Re: Application 3/2025/0877 - Approval of details reserved by conditions 4 (Walling and roofing materials), 5 (Roof Lights), 6 (Windows and Doors) and 7 (Stone Flags) on planning permission 3/2025/0231. 3 Church Street Clitheroe BB7 2DD

These comments are on behalf of Clitheroe Civic Society.

MATERIAL SCHEDULE
JANUARY 2025

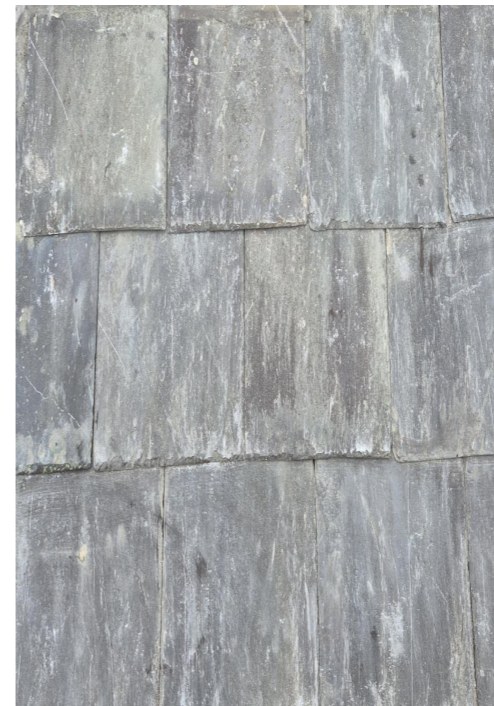
We have reviewed the details submitted towards satisfying conditions 4, 5, 6 and 7 of application 3/2025/0231, and we welcome the intention to carefully remove, store and mark the historic stone flags for their reuse as part of the scheme. We would urge caution in the re-use of reclaimed materials such as flag and roofing slates, however, unless these are from a legitimate provenance. Modern replicas made using traditional quarrying methods can be a better option.

**03-206 - Proposed Window & Door Details**

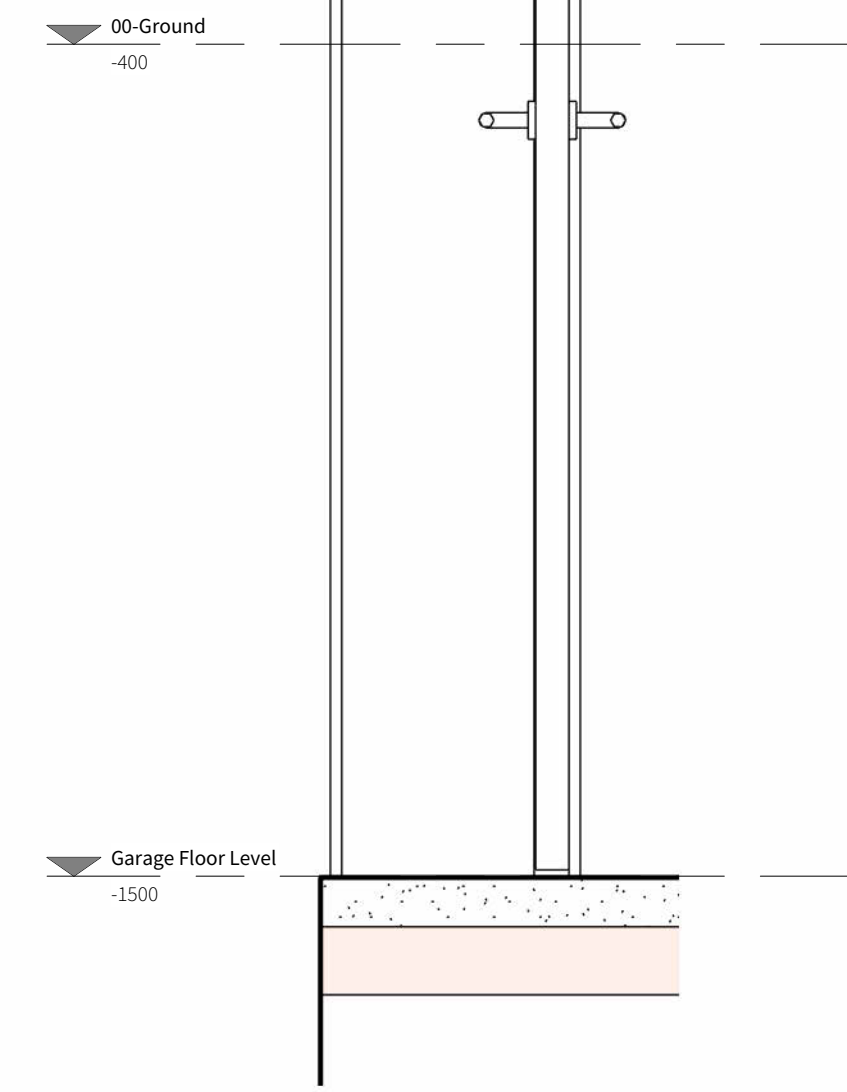
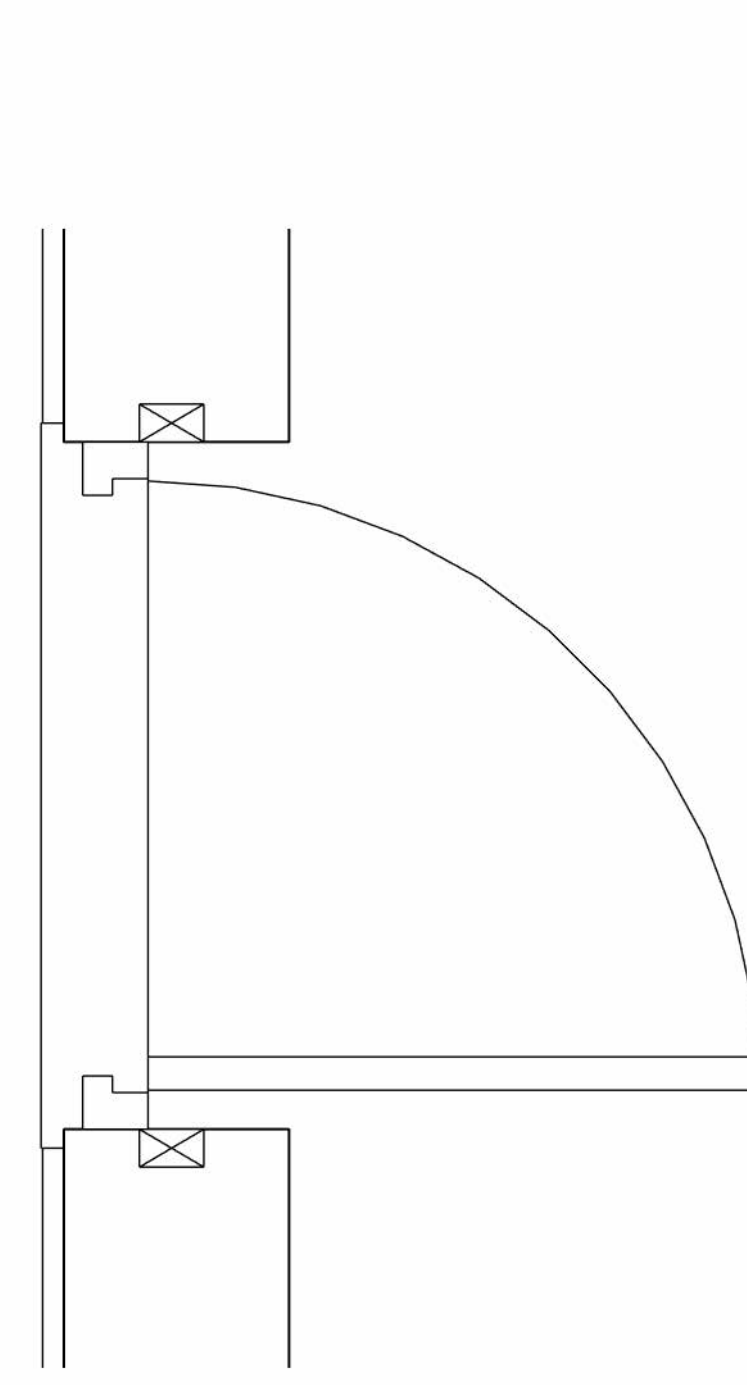
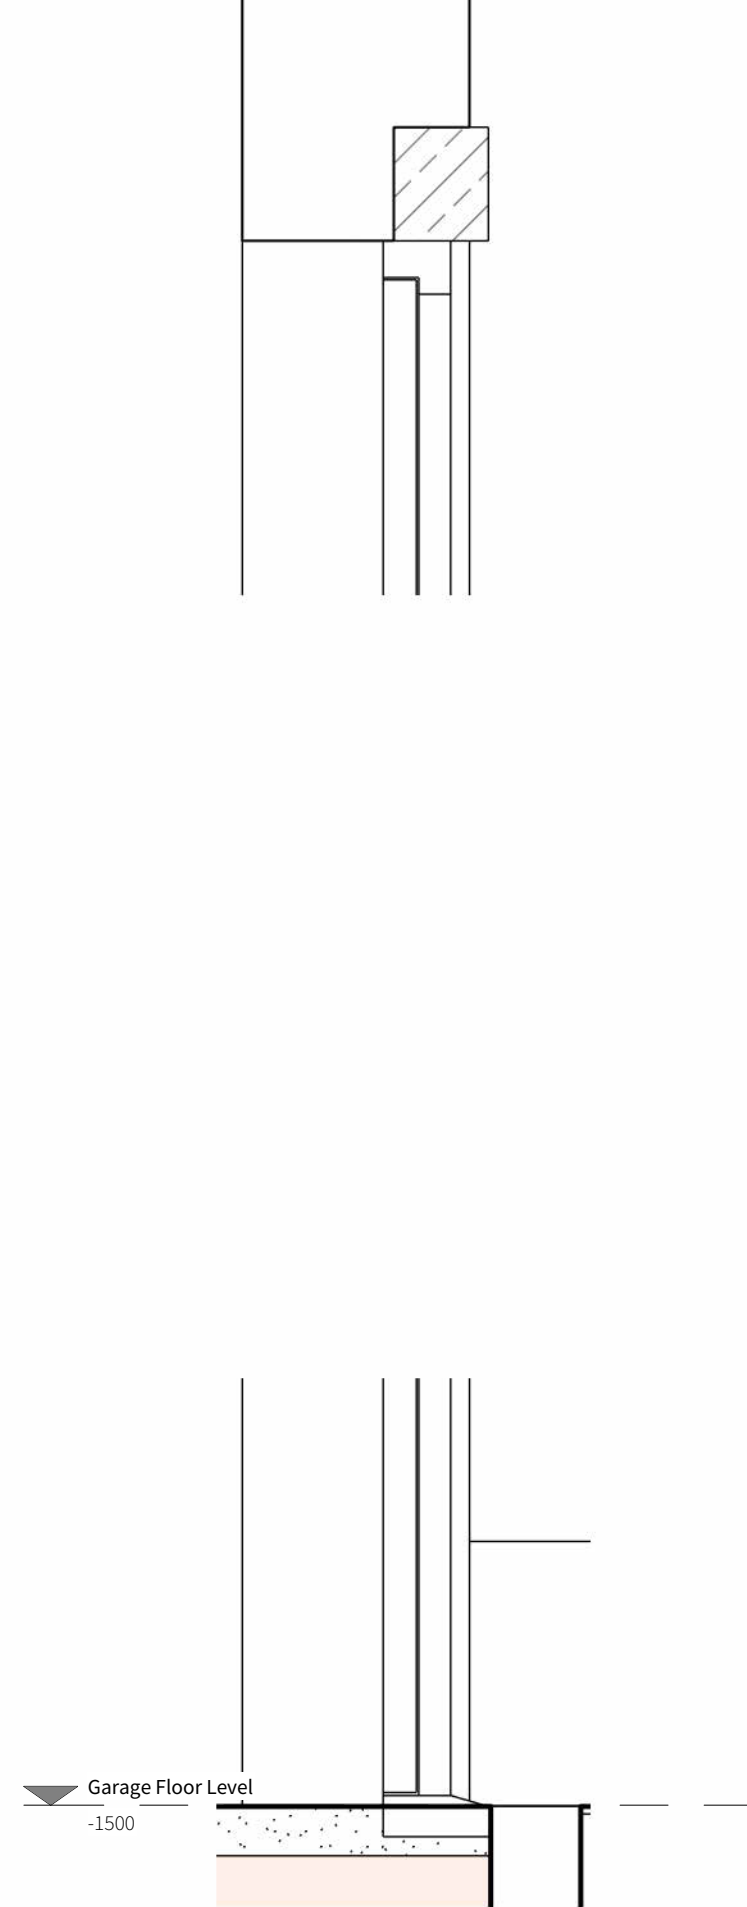
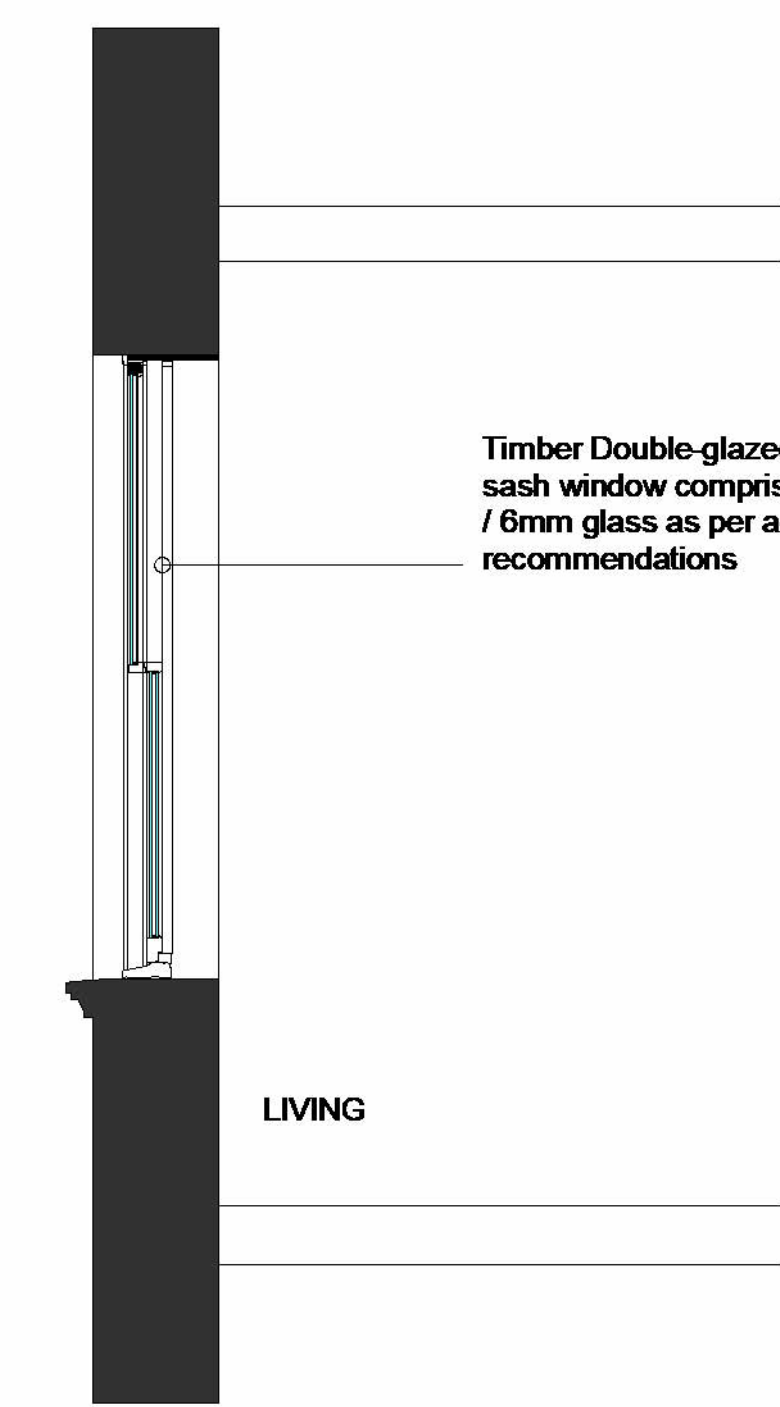
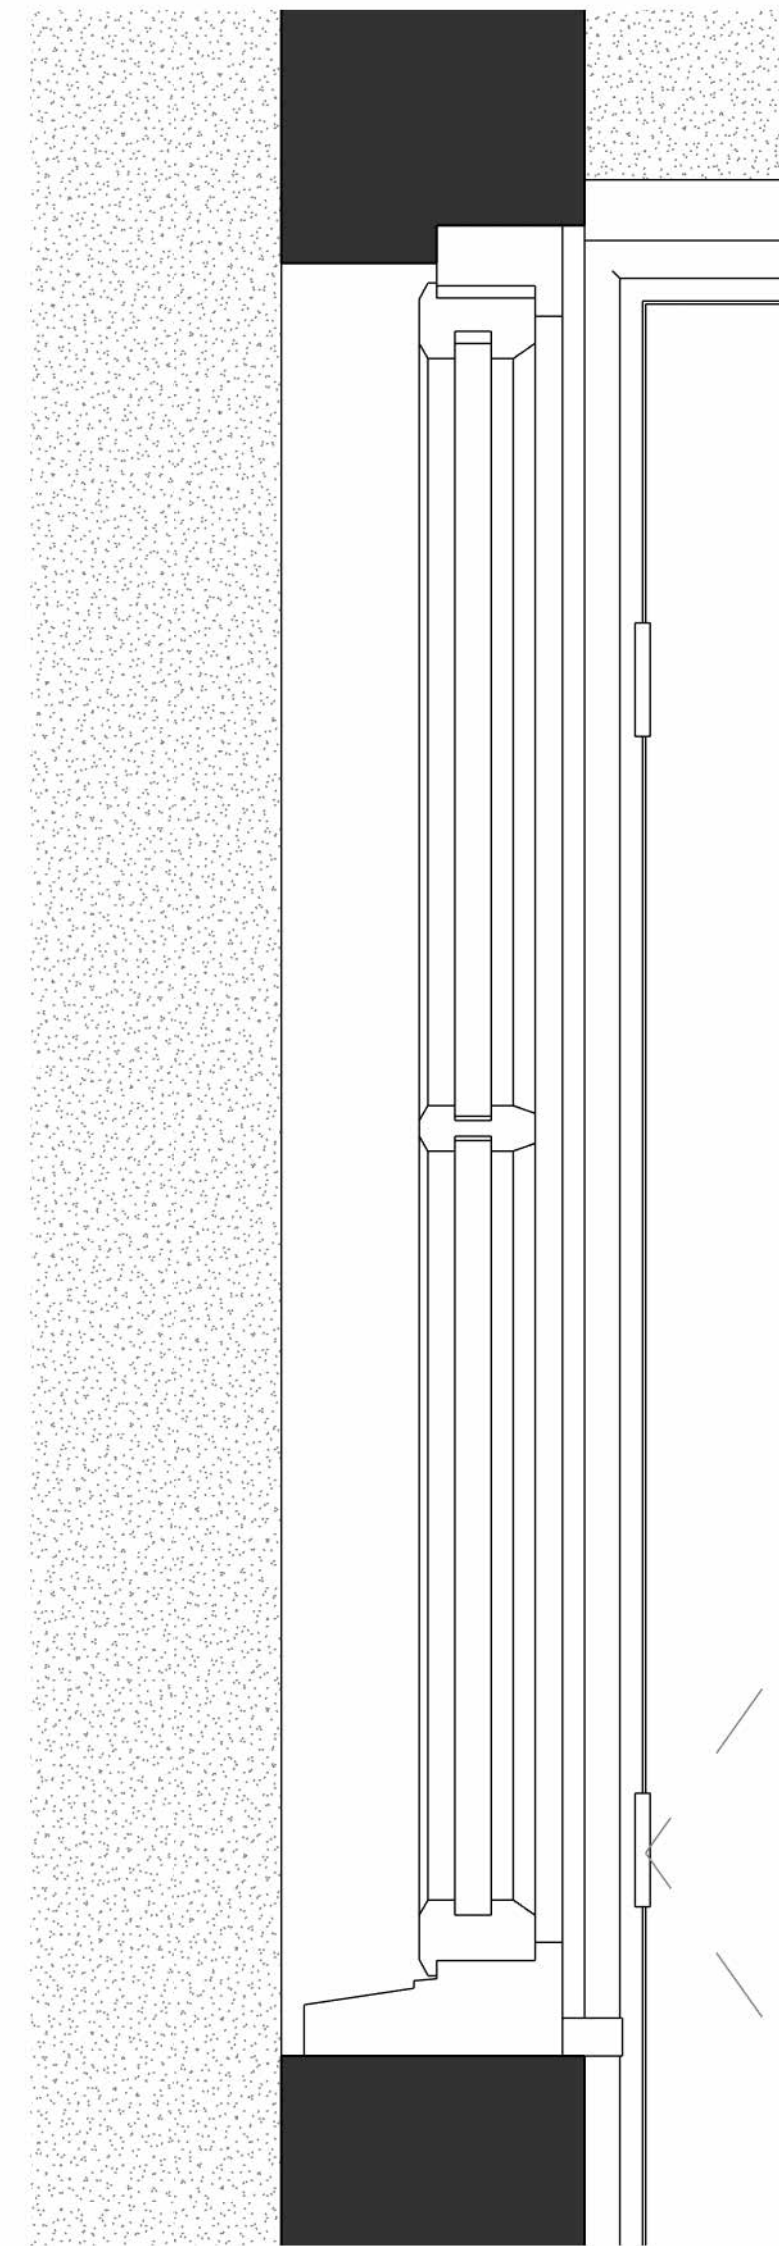
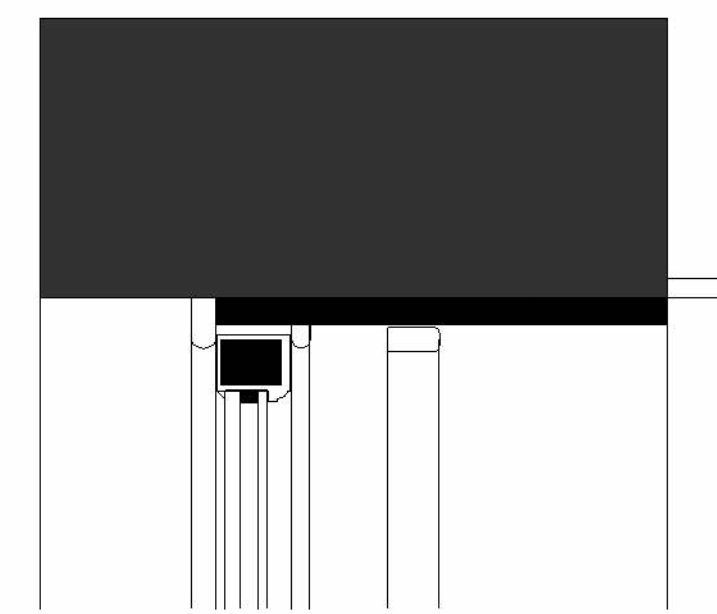
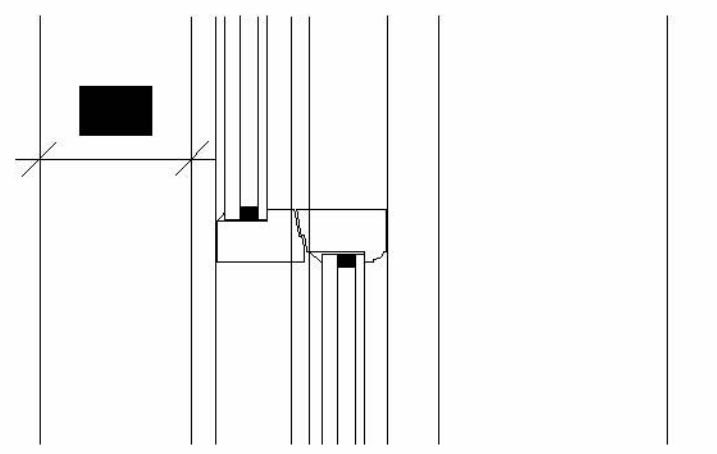
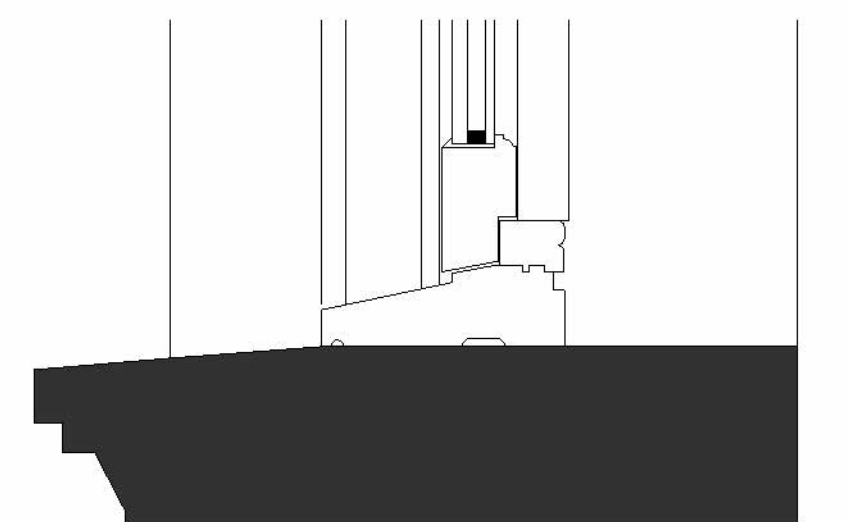
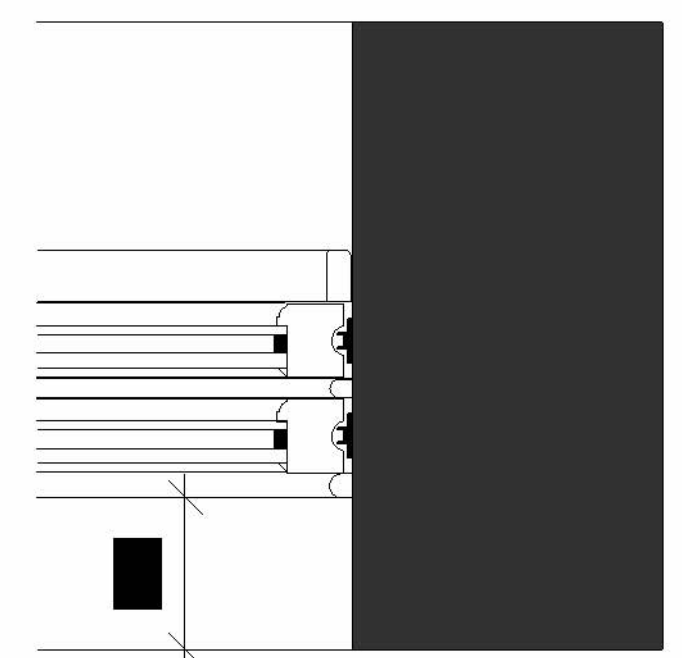
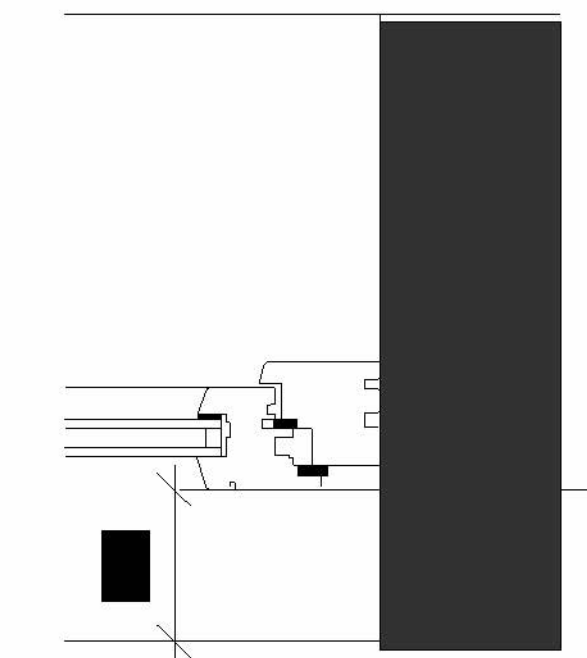
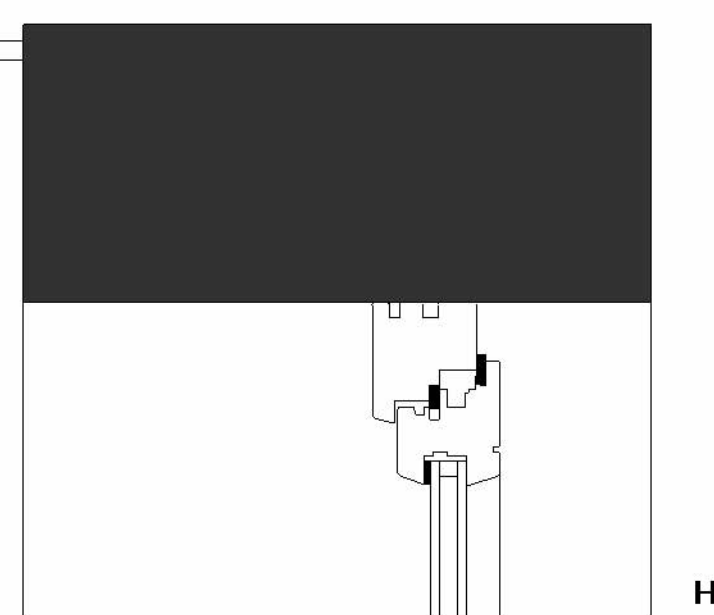
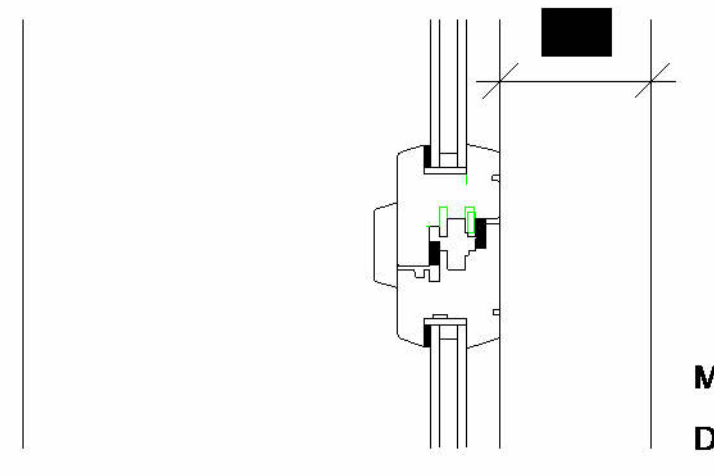
We have concerns regarding the proposed windows. We commented on an earlier application for this site that there was no survey of the existing windows, or discussion of their historical significance or condition. The application has therefore not justified why the existing windows cannot be repaired and retained. Clitheroe Conservation Area Management Guidance states: *'As a rule, windows in historic buildings should be repaired, or if beyond repair should be replaced 'like for like'. It is important that the design, scale and proportion of new windows should be sympathetic to the character of the building.'* The proposed windows are a mock sash design, which is not a like for like replacement. The frames are too chunky and out of proportion with the building and with the other buildings on the street. They are not appropriate for use on a listed building or within Clitheroe Conservation Area, and would cause harm to the significance of both the grade II listed building and the designated Conservation Area. We recommend that the applicant undertakes a window condition survey and frames should be retained and repaired wherever possible, with thermal upgrades such as secondary glazing added. Where frames are beyond repair, then full sliding timber sash windows of the same proportions as the existing should be used. Guidance on windows in historic buildings can be found here: <https://historicengland.org.uk/images-books/publications/traditional-windows-care-repair-upgrading/heag039-traditional-windows-revfeb17/>
